Colston Budd Rogers & Kafes Pty Ltd

12 February, 2020

RE: EASTLAKES SHOPPING CENTRE
RESPONSE TO AGENCY SUBMISSIONS

Figure 44 | Proposed lengthening of right turn lane of Gardeners Road (shown red) and location of bus stops (shown yellow) (Base image source: Proponent's SRTS)

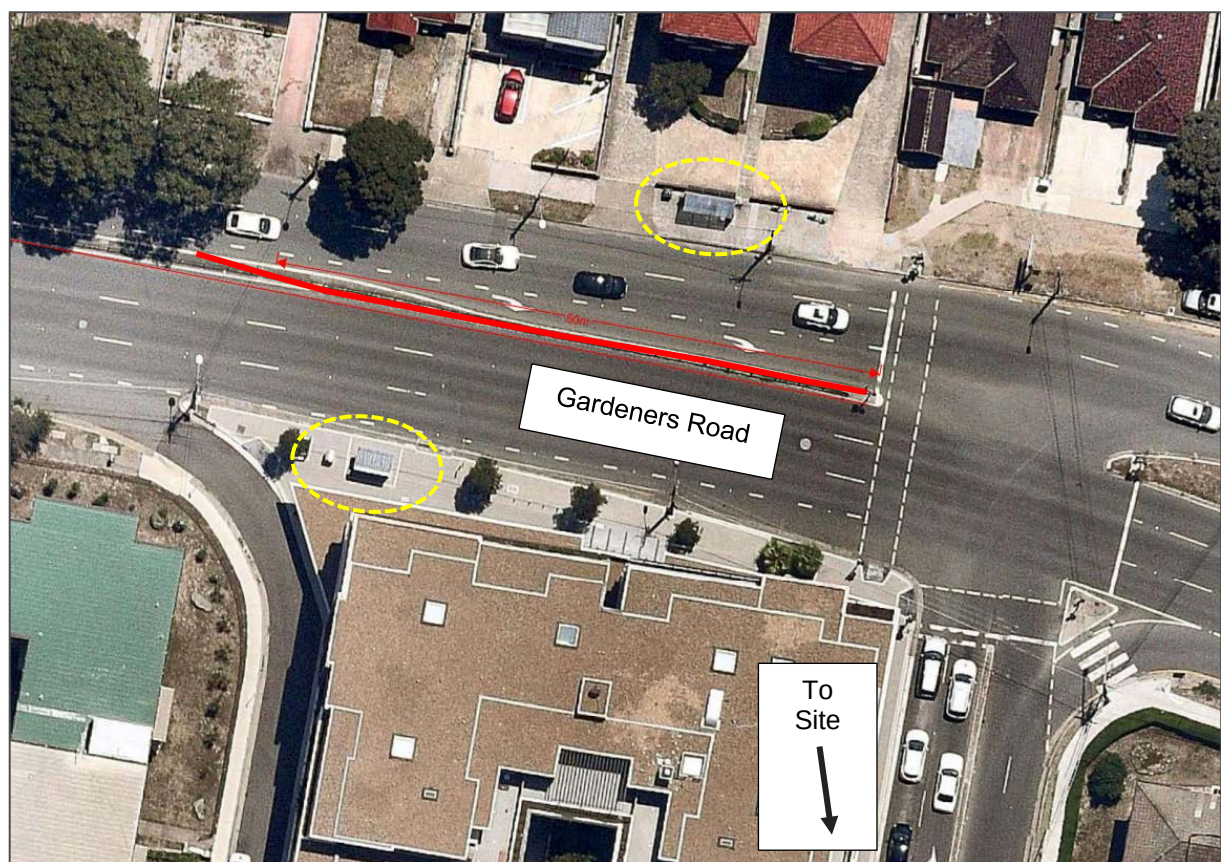
“The modelling provided in the RtS suggests that the right turn lane from Gardeners Road into Racecourse Place will be beyond capacity causing safety and efficiency concerns for Gardeners Road, which is a classified state road. This is particularly evident during Saturday peak periods. TfNSW recommends that the proponent review the modelling and propose appropriate mitigation measures to ensure that the modification does not compromise the safety and efficiency of Gardeners Road.”

2. We have reviewed the SIDRA modelling and note the following:
 - the existing right turn lane on Gardeners Road is some 35 metres long plus taper;
 - with traffic from approved development the longest 95% back of queue in the right turn bay occurs on Saturday at some 36 metres;
 - with additional traffic from the S75W the 95% back of queue extends by some 5 metres.
3. Thus the additional S75W traffic increases the 95% back of queue in the right turn bay by less than one vehicle. Given that this occurs one or two cycles in the busiest hour per day and that in practice such a minor exceedance in the

4. Nonetheless to address the issue raised by TfNSW it is proposed to extend the right turn bay to some 45 metres plus taper as shown in the attached concept sketch.
5. We trust the above provides the information you require. Finally, if you should have any queries, please do not hesitate to contact us.
